**CHARLOTTE - MECKLENBURG  
 PLANNING COMMISSION  
 INTER - OFFICE COMMUNICATION**

**SUBJECT:** Administrative Approval for Petition No. 2005-46, Coogan's General Contracting

**CONDITIONAL REZONING REQUEST
AND TECHNICAL DATA**

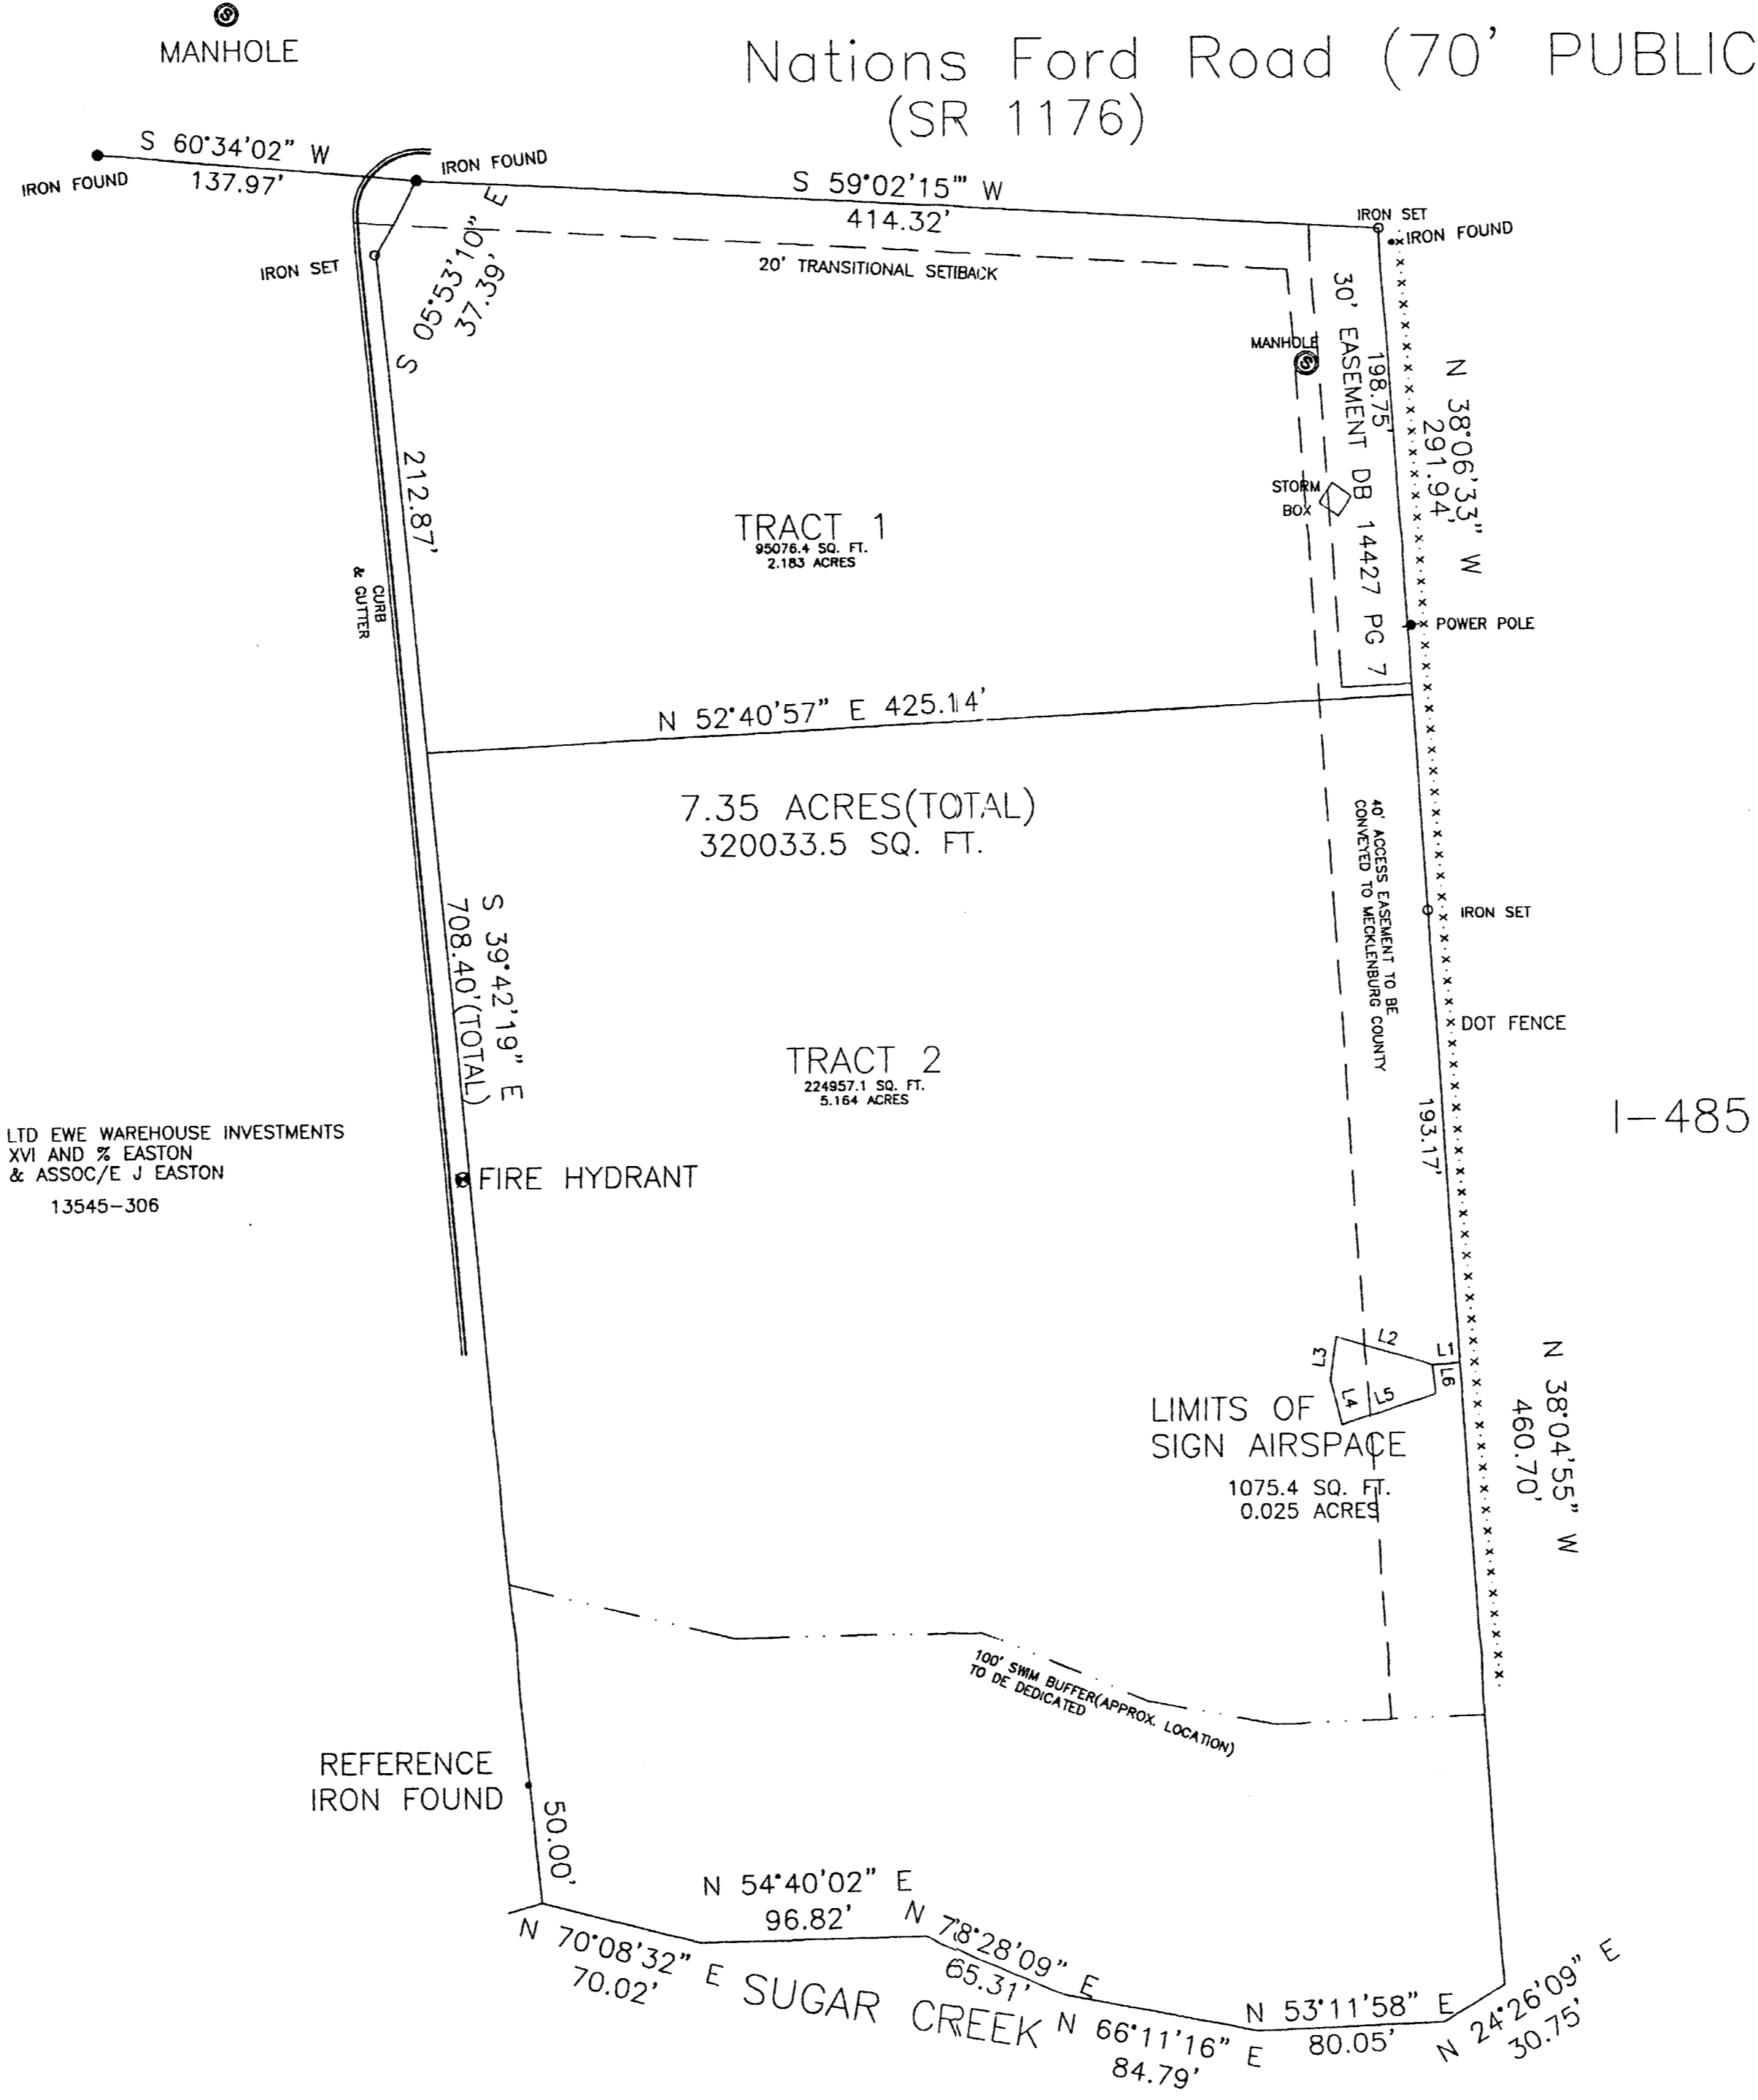
Attached is a revised plan for the above petition. The plan has been revised to show a transition from an 8-foot planting strip with a 6-foot sidewalk to a 5-foot sidewalk with a 4-foot planting strip along Nations Ford Road. This transition is needed because of a conflict with a guard rail. The plan also notes that dedication of additional right-of-way along Nations Ford Road will occur prior to the issuance of a certificate of occupancy rather than a building permit. Since these changes do not alter the intent of the development and meet the requirements of the Charlotte Zoning Ordinance Section 6.207 Alterations to Approval, minor changes, I am administratively approving this plan. Please use this plan when evaluating requests for building permits and certificates of occupancy.
